Woodgate Nurseries and Adjacent Lane

Proposal for up to 150 residential dwellings

Technical Note in Response to WSCC Highways Comments
(2401/TN/04)

October 2024

Pedestrian/Cycle Access (HTp/2401/04/C)

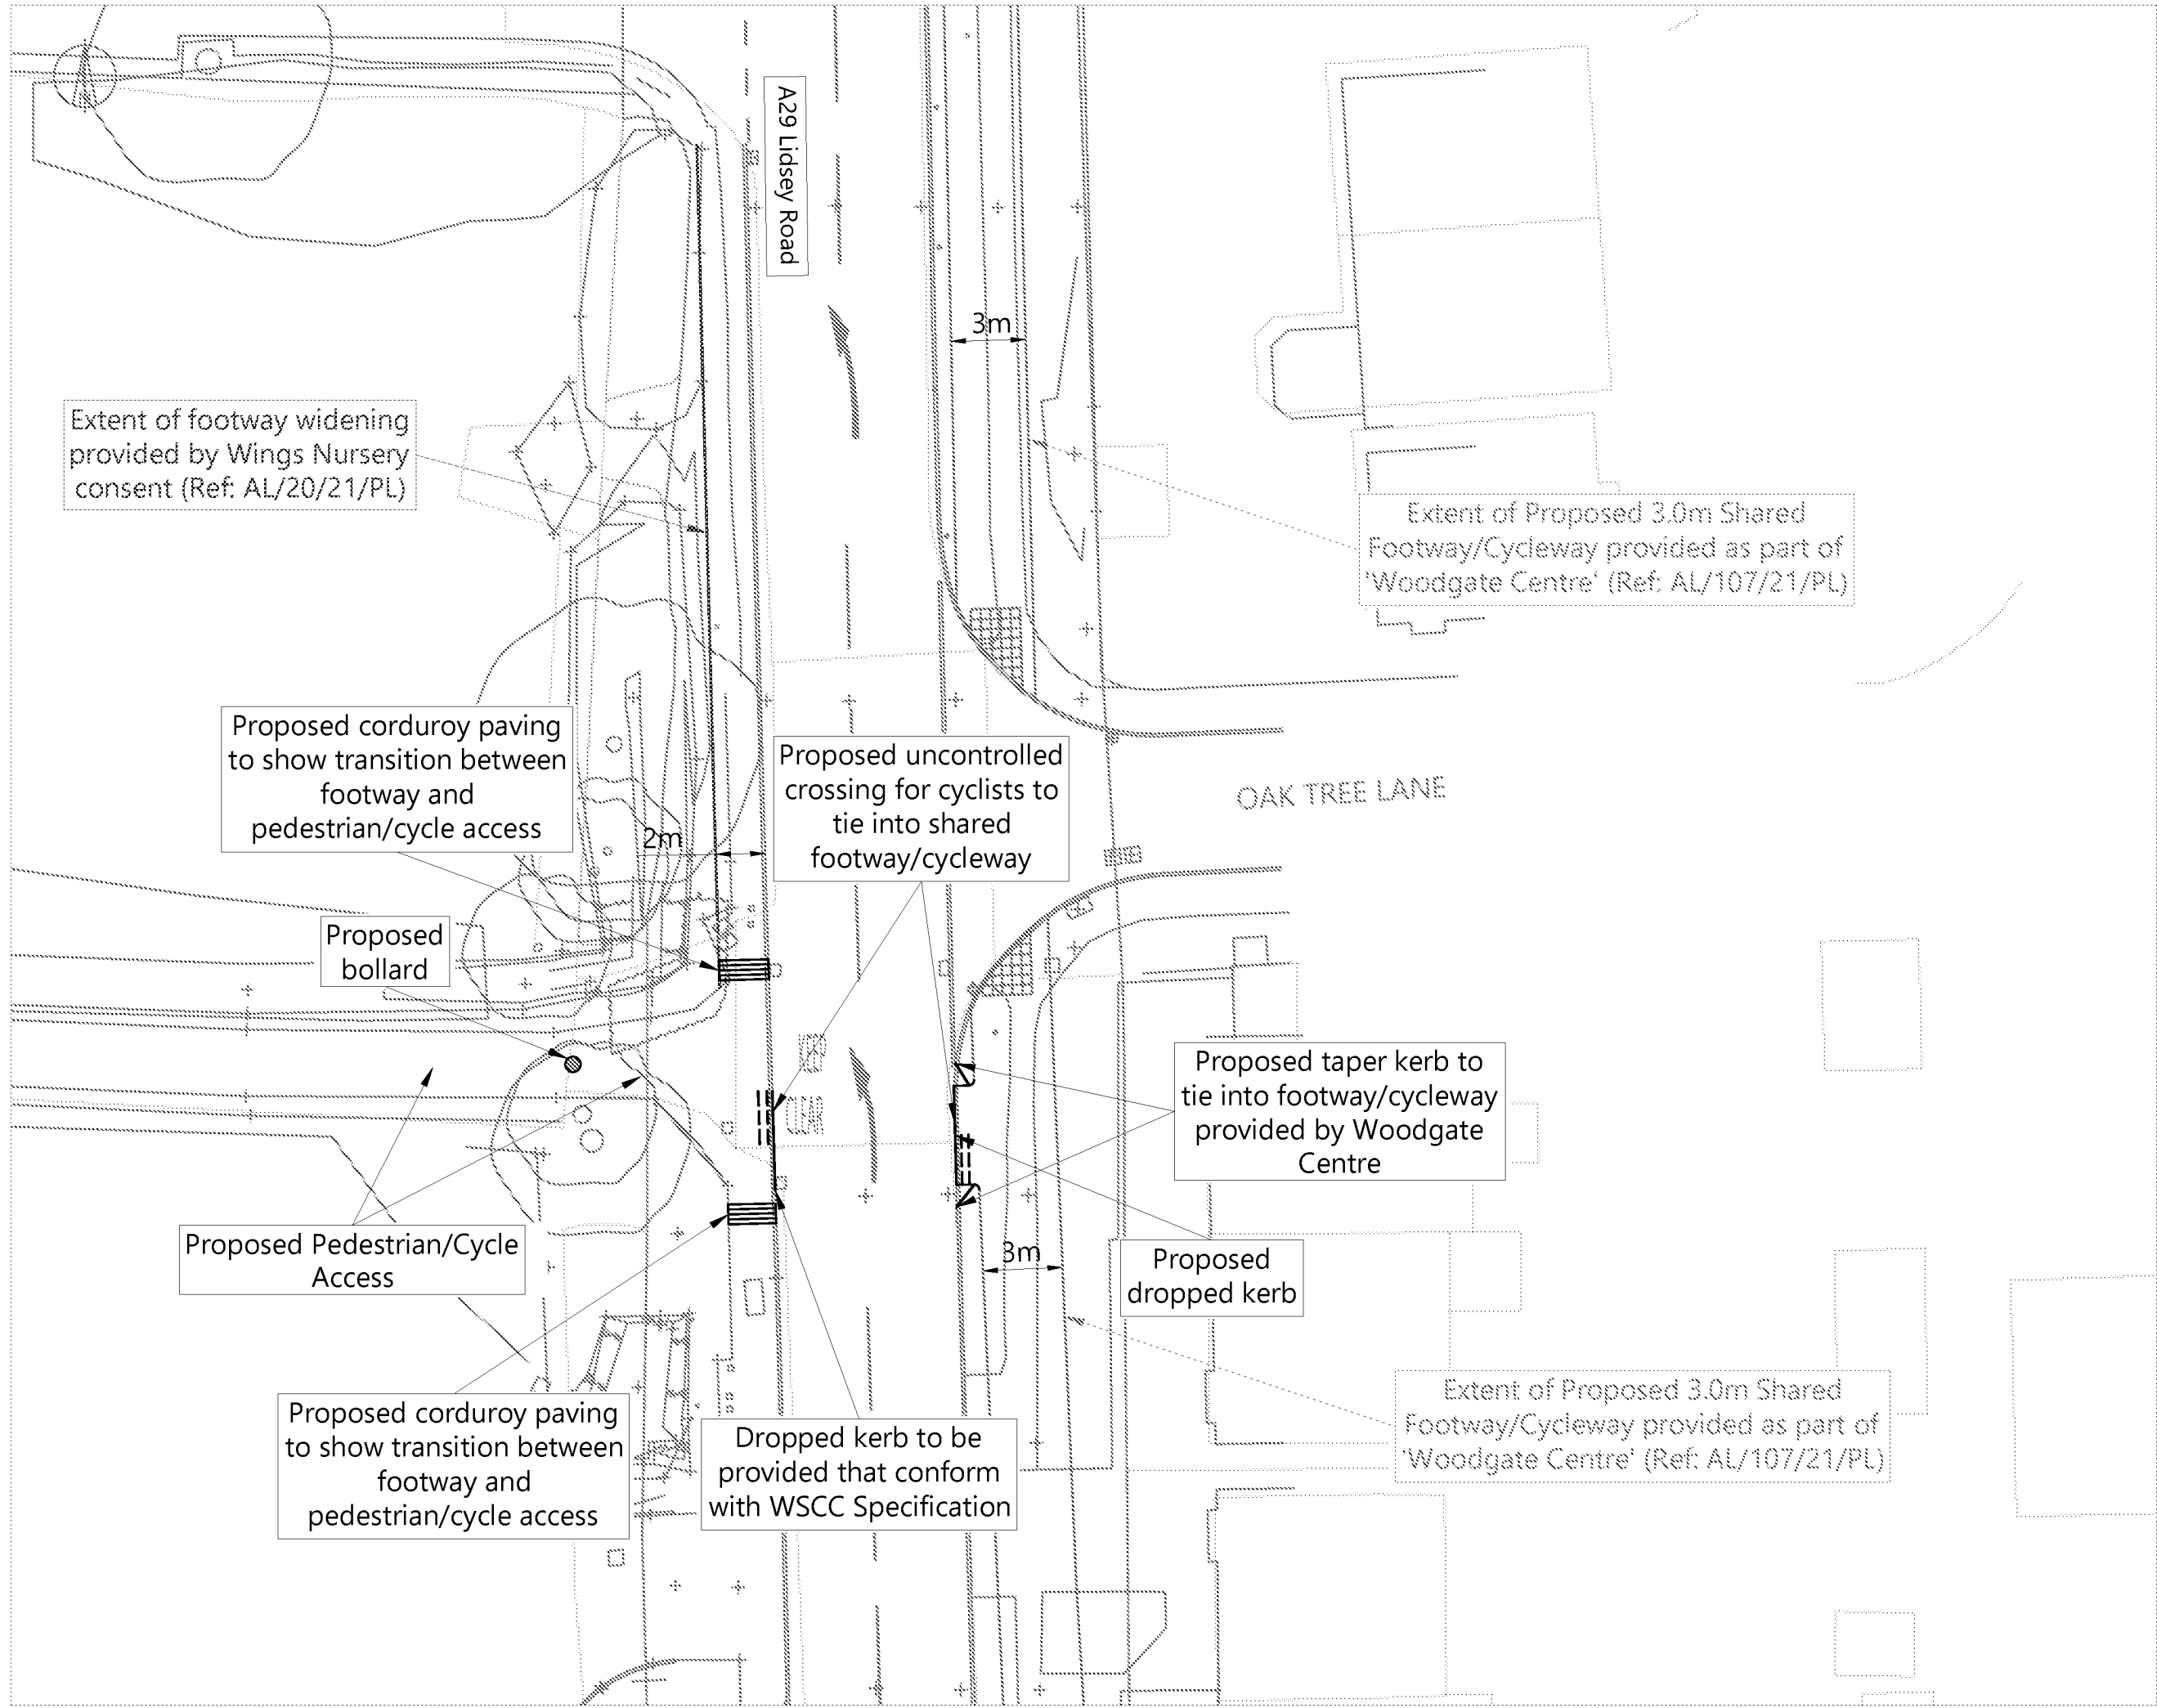
- iii. A plan demonstrating the design details of the foot, cycle and emergency connection to the A29, with the plan including how the proposed works interface with the proposed works as part of the Woodgate Centre off-site foot and cycle works

- 2.14 WSCC Highways have requested that a plan is provided which shows the design details of the pedestrian, cycle and emergency vehicle access which connects to the A29 Woodgate Road, with the plan showing how the proposed works interface with the works proposed as part of the nearby Woodgate Centre off-site pedestrian and cycle works.

the site for pedestrians and cyclists and emergency purposes. However, further detail of this, including its connection with the existing A29 and how such works interface with off-site foot and cycle highway improvements proposed as part of the nearby Woodgate Centre scheme, should be provided.

- 2.15 Drawing HTP/2401/04/C, contained in **Appendix 4** demonstrates how our proposals will tie into the 3.0 metre wide shared footway/cycleway provided as part of the Woodgate Centre proposals, including a crossing.

- 2.16 This plan has been provided to the highway officer under separate cover and it has been confirmed by WSCC Highways that there are no further comments on the proposals, and that signage and road markings will be considered in detail at the detailed design stage. Email correspondence is contained in **Appendix 5**.
